# STERLING RANCH ROAD & BRIARGATE PARKWAY GESC

## COUNTY OF EL PASO, STATE OF COLORADO GRADING AND EROSION CONTROL PLANS DECEMBER 2021

EPC STORMWATER REVIEW COMMENTS  
IN ORANGE BOXES WITH BLACK TEXT

SHEET 3 OF 9
 JOB NO. 25188.03

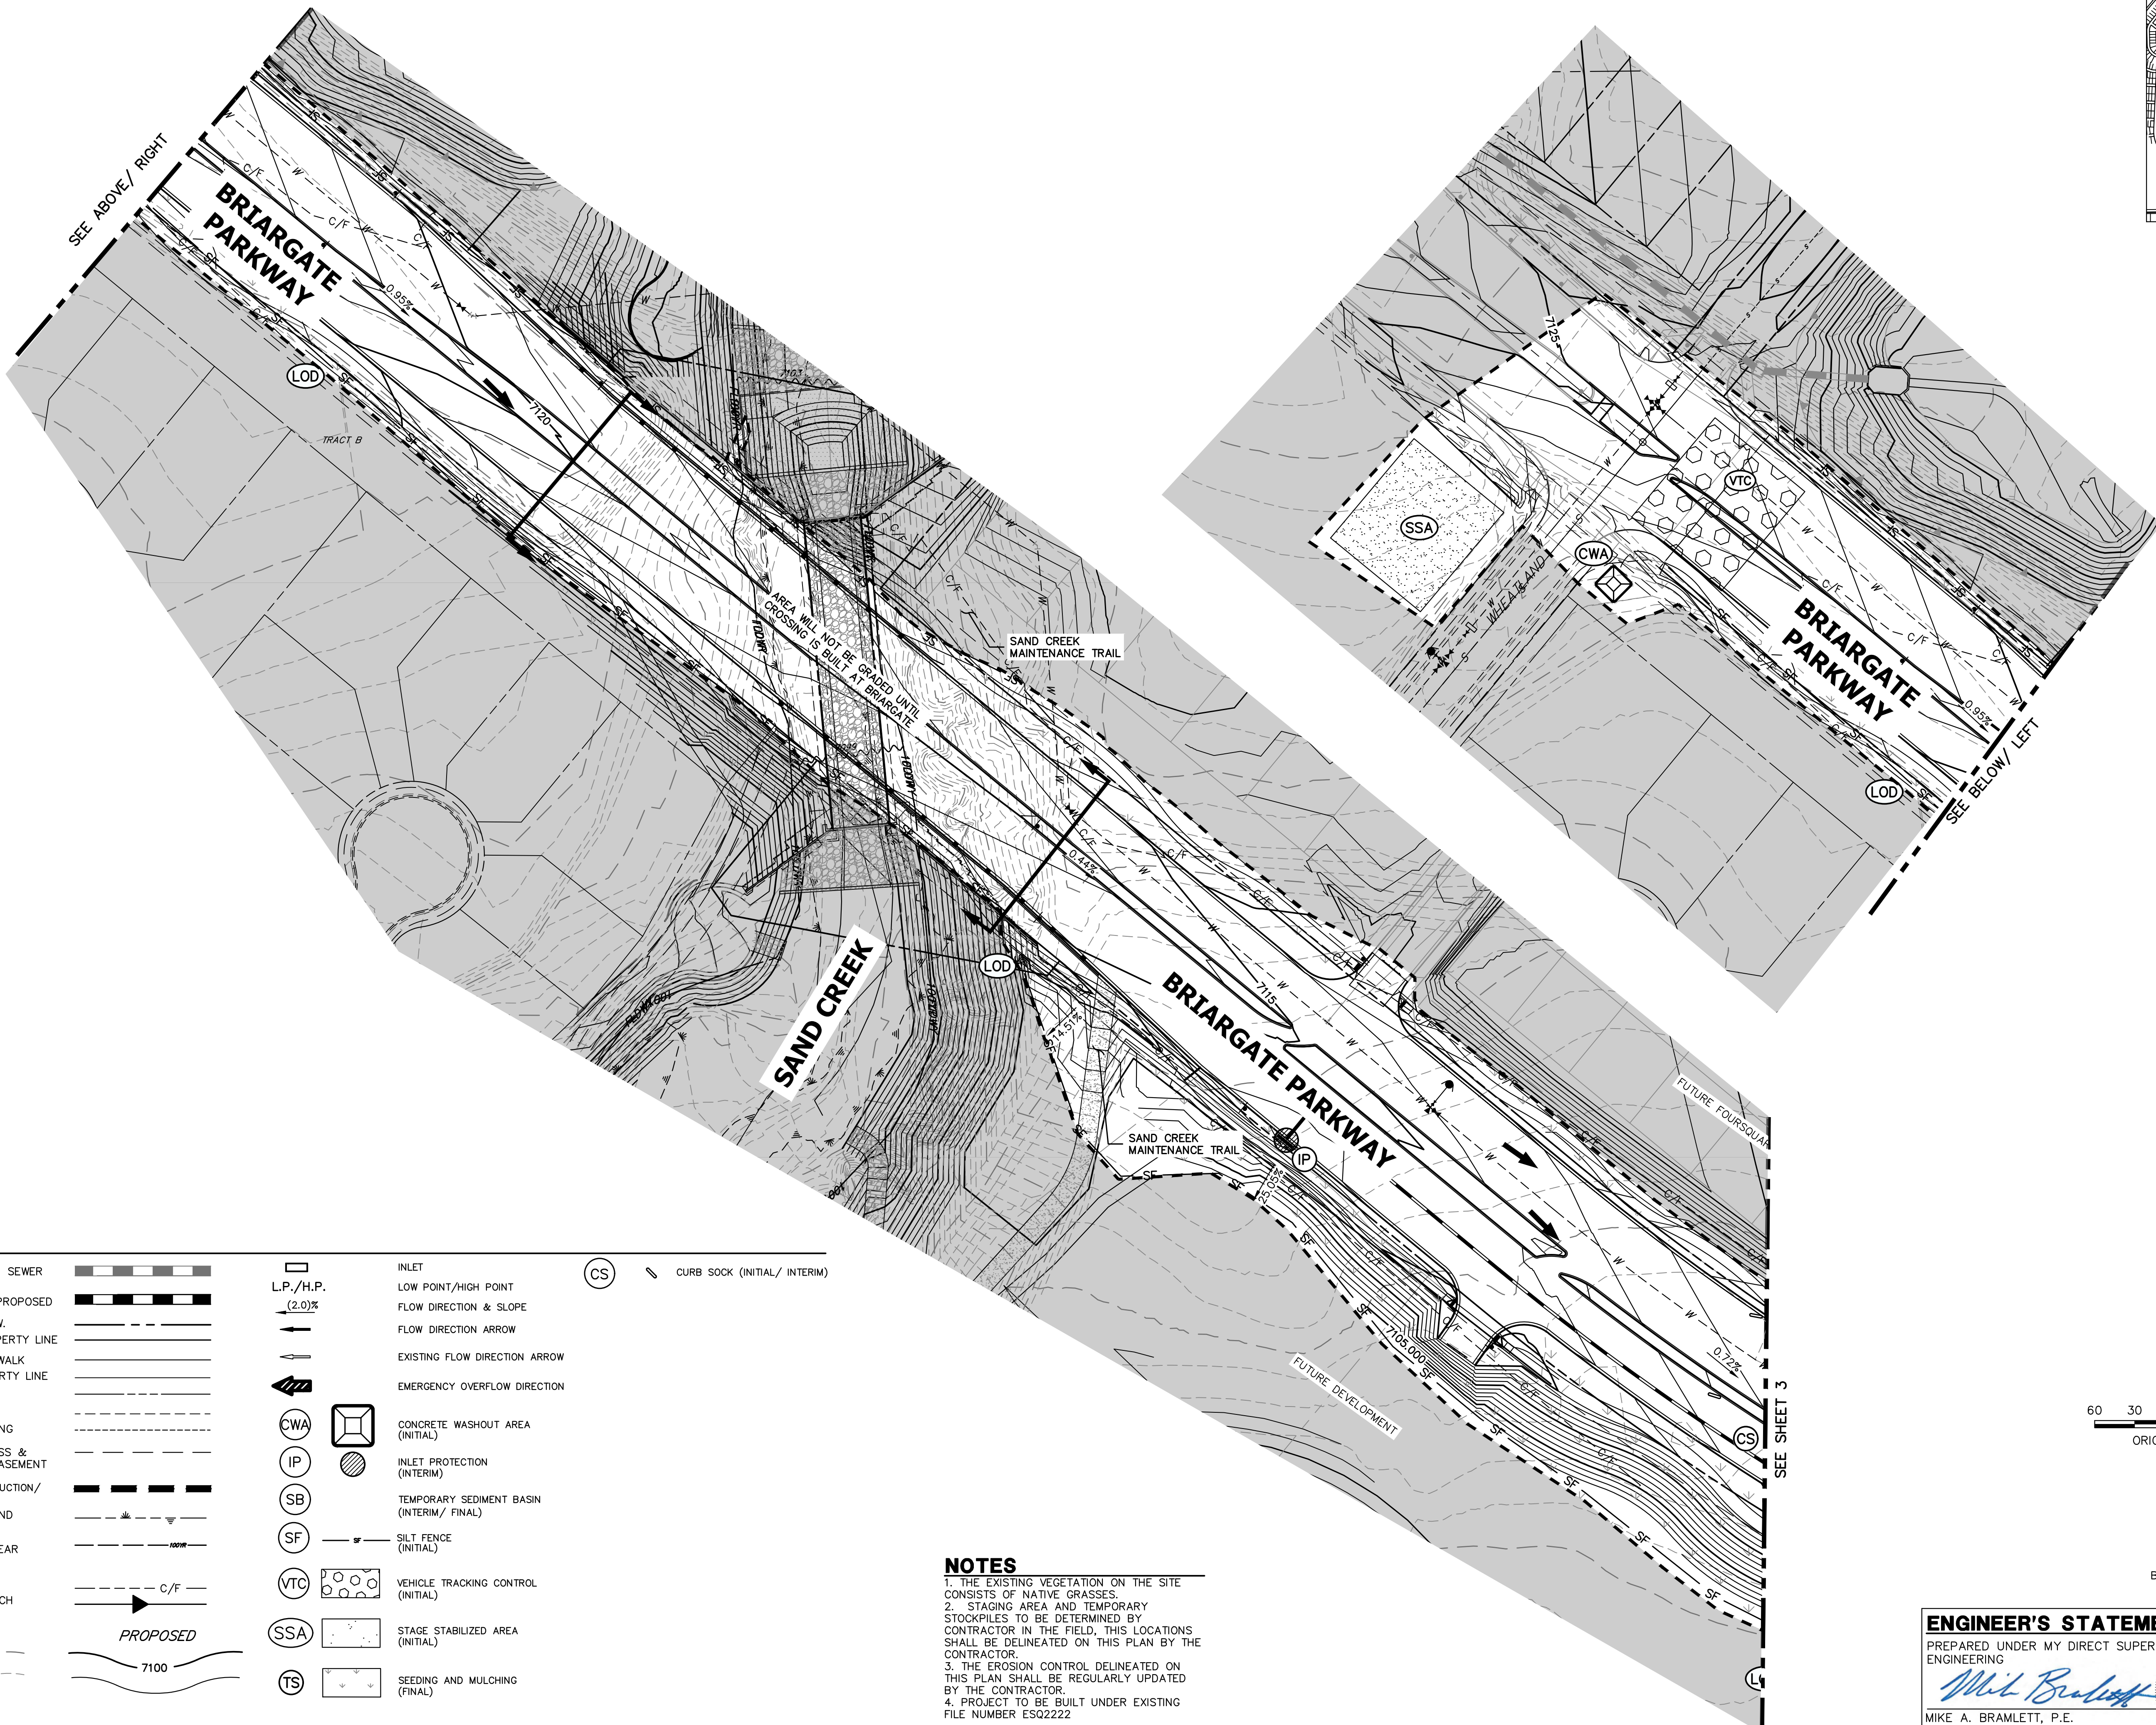
- Rock check dams shown on FAE Form. Show them on plans here and in Legend below.

add a column next to BMPs to label each as "initial," "interim," and "final" or create a separate table.

Label as a Section or should there be mirrored arrows on the other side of the bridge like bridge on Sht 6??

Missing access along channel, as shown on drainage plans. Please add Address how steep grading will work with access coming off of BGP

label grade of steeper slopes throughout site.

show locations on plans, or make note that location is TBD by contractor.

revise to "seeding and mulching?" Mulching shown on FAE form.

show locations on plans

- GEC Checklist Item "B" - label adjacent subdivisions.  
- Item "I" - discuss existing vegetation in a note.  
- Item "S" - show drainage flow arrows on plans and legend.  
- Item "U" - show location of staging and stockpiles on plans.  
If locations are TBD, notate this on plans.

label major contours
